Application Reference: 2026/0339

Site Address: 10 Whinmoor Way, Silkstone, Barnsley. S75 4JE

Introduction: This application seeks full planning permission for the erection of single storey rear extension and raised patio, front porch, new pitched roof to replace flat roof on side garage and widening of front drive to dwelling.

PROPOSED - PARAPET ROOF
REDUCED EXTENSION

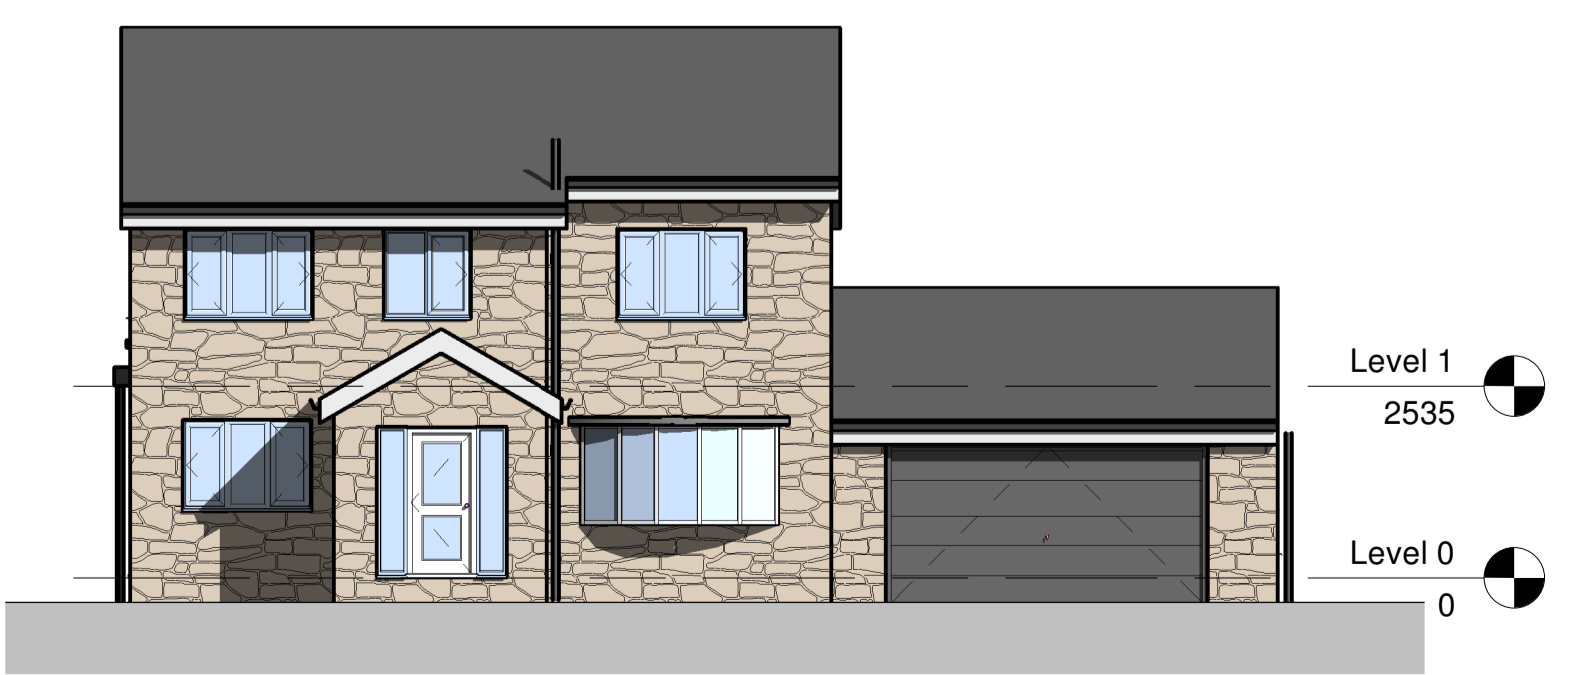
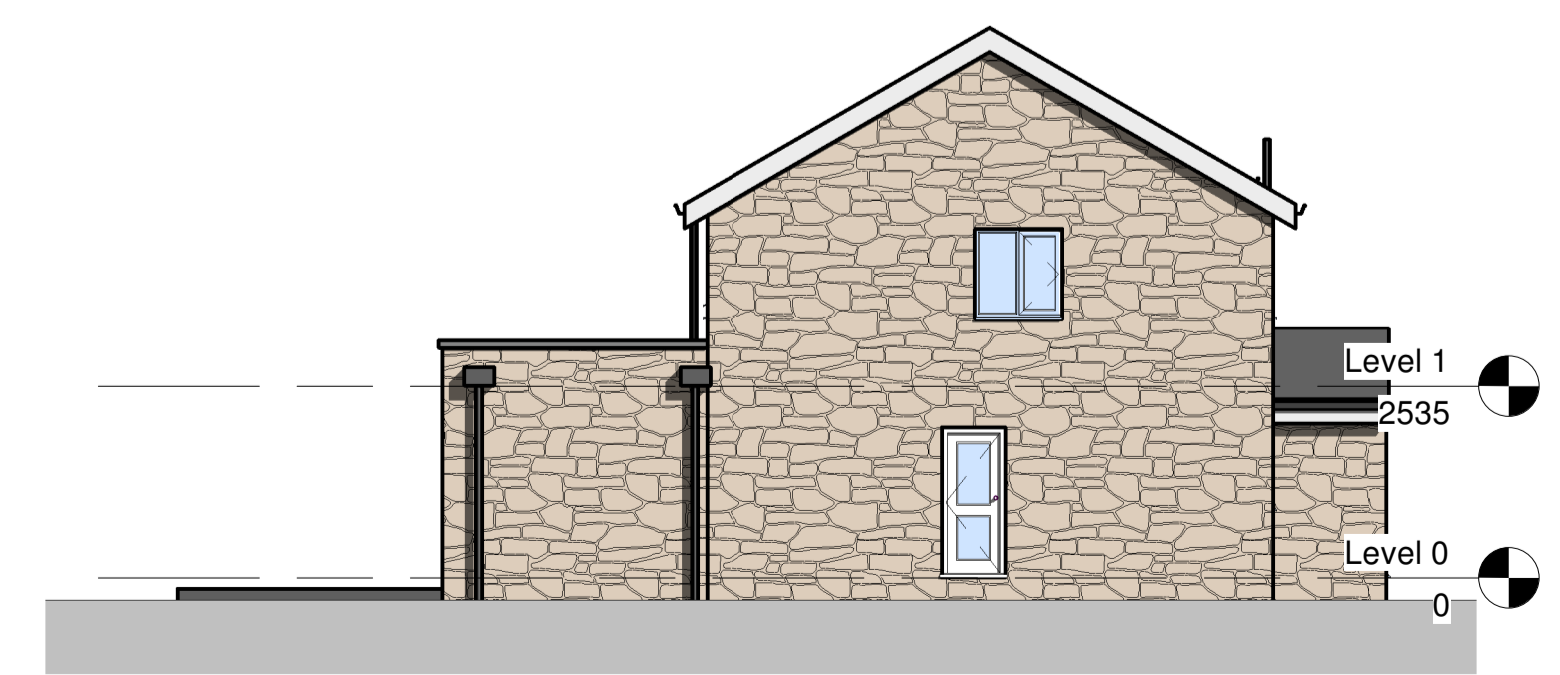
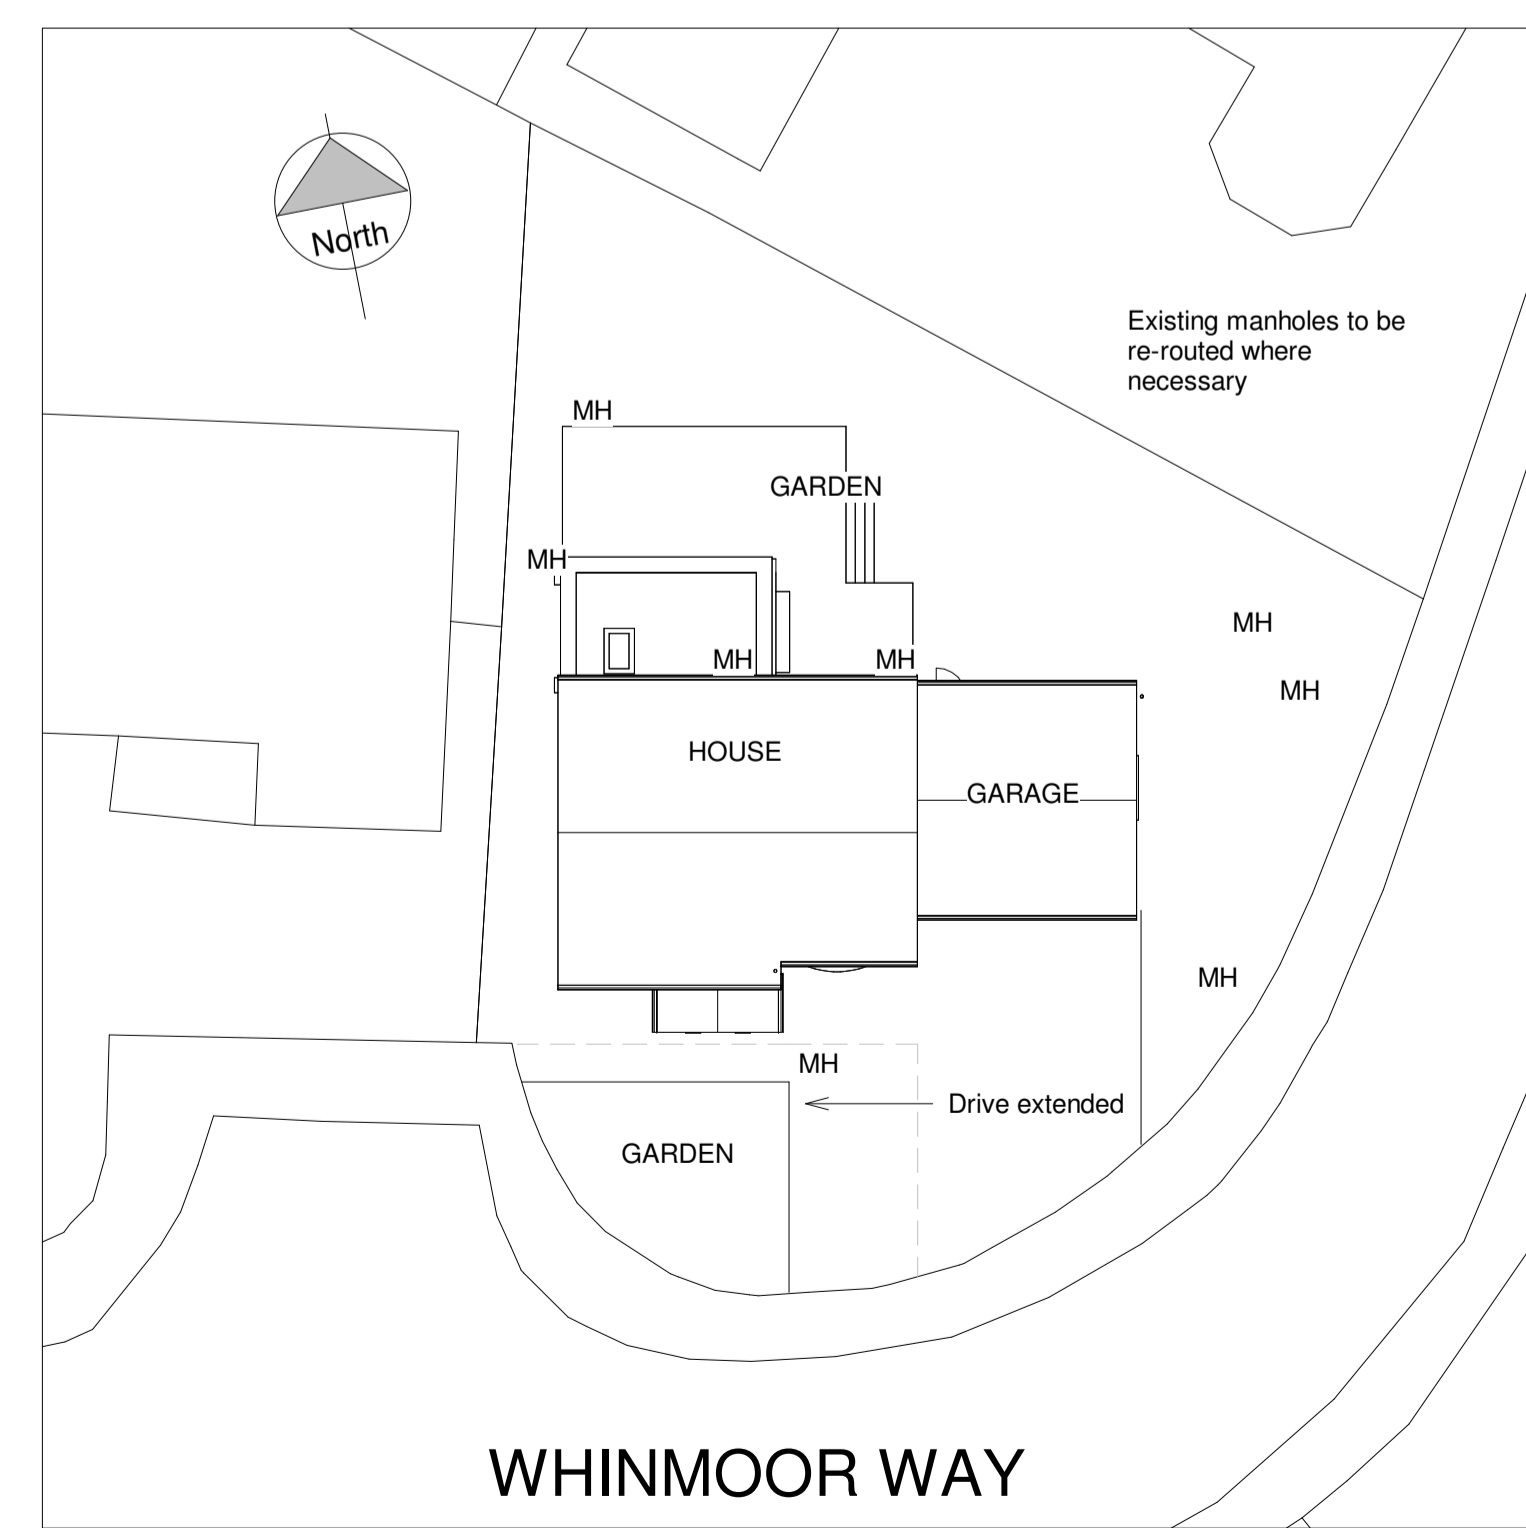
An extension with a modest sized rear projection of 3.5m, below the 4m allowable through permitted development, along with a modest width of around 5.65m are proposed for the rear elevation. In addition to this flat roof extension, a raised patio area is proposed. Whilst the extension would be at the same ground level as the front elevation of the dwelling, the proposed raised patio, which the extension is built upon, is used to correct the ground level difference between the front and rear elevations of the dwelling.

From the actual ground level at the rear of the dwelling, the roof height of the proposed extension would be approximately 4.1m. From the height of the raised patio, the height of the extension is only

3.3m. In comparison, at their highest points from the same ground level, the height of the original dwelling is approximately 8.3m, whilst the existing flat roof garage has an approximate existing height of 3.1m and a proposed new pitched roof height of 4.92m. Both the existing external, rear door of the garage and patio doors of the dwelling stand around 0.75m and 0.95m respectively above ground level.

With the raised patio correcting a potential design flaw of the original dwelling, which currently requires steps from the rear patio doors to the rear garden, it also creates a potential new issue, by artificially raising the ground level of the rear garden above the 0.3m allowable through permitted development. The maximum height of the proposed patio would be approximately 0.85m above the ground level. The total gross area of the patio, including steps is approximately 243 sqm, with a net area of 148 sqm once the steps and footprint of the extension are excluded. At 148 sqm, the patio remains a considerable size but is equally acceptable in comparison to the original 400 sqm of garden (after the house has been excluded).

In terms of design, a pitched roof extension may have been an improvement, but such a feature would have raised the height of the extension's roof considerably, and almost certainly had a negative impact on residential amenity, so a flat roof is perfectly acceptable. Proposed stonework and tiles are proposed to match the existing dwelling, and whilst window materials and colours are to be confirmed, the indicated proportions, along with the proposed aluminium bi-fold doors are acceptable and would have limited impact on the design and character of the dwelling.

The extension itself, as noted above is of an overall modest scale, with the flat roof compensating for the increased height of the extension, caused by a lower ground level of the garden compared to the actual ground floor level of the dwelling. There is a window proposed on the eastern elevation of the extension, but this ground floor window would only directly overlook the applicant's garden for approximately 16m. Rear glazed doors are also proposed, but these are again essentially ground floor windows and are set around 9m from the relatively strong rear boundary treatment. There are no windows proposed for the western elevation, adjacent to the neighbouring dwelling of no 12.

As noted there would be no concern of overlooking from the extension to any neighbouring dwellings, but given the maximum height of the extension, there may be an impact of overbearing on the neighbouring dwelling of no 12, particularly to a large, side elevation window. Whilst this is not desirable, there are aspects of mitigation. Firstly, as noted, although the proposed extension would be higher than what may be permissible by permitted development, a longer 4m extension, with an appropriate roof height could be constructed without planning consent. Whilst the extension is also close to the boundary, the total distance between the side elevation and window is

approximately 3.85m, and with the window being east facing, any impact on sunlight levels would be most significant in the early morning. Finally, the ground level of no 12 is higher than the ground level of the application dwelling, reducing potential impact. However, whilst the extension would have a general limited impact on residential amenity, specifically for no 12, the level of impact would be considered as moderate.
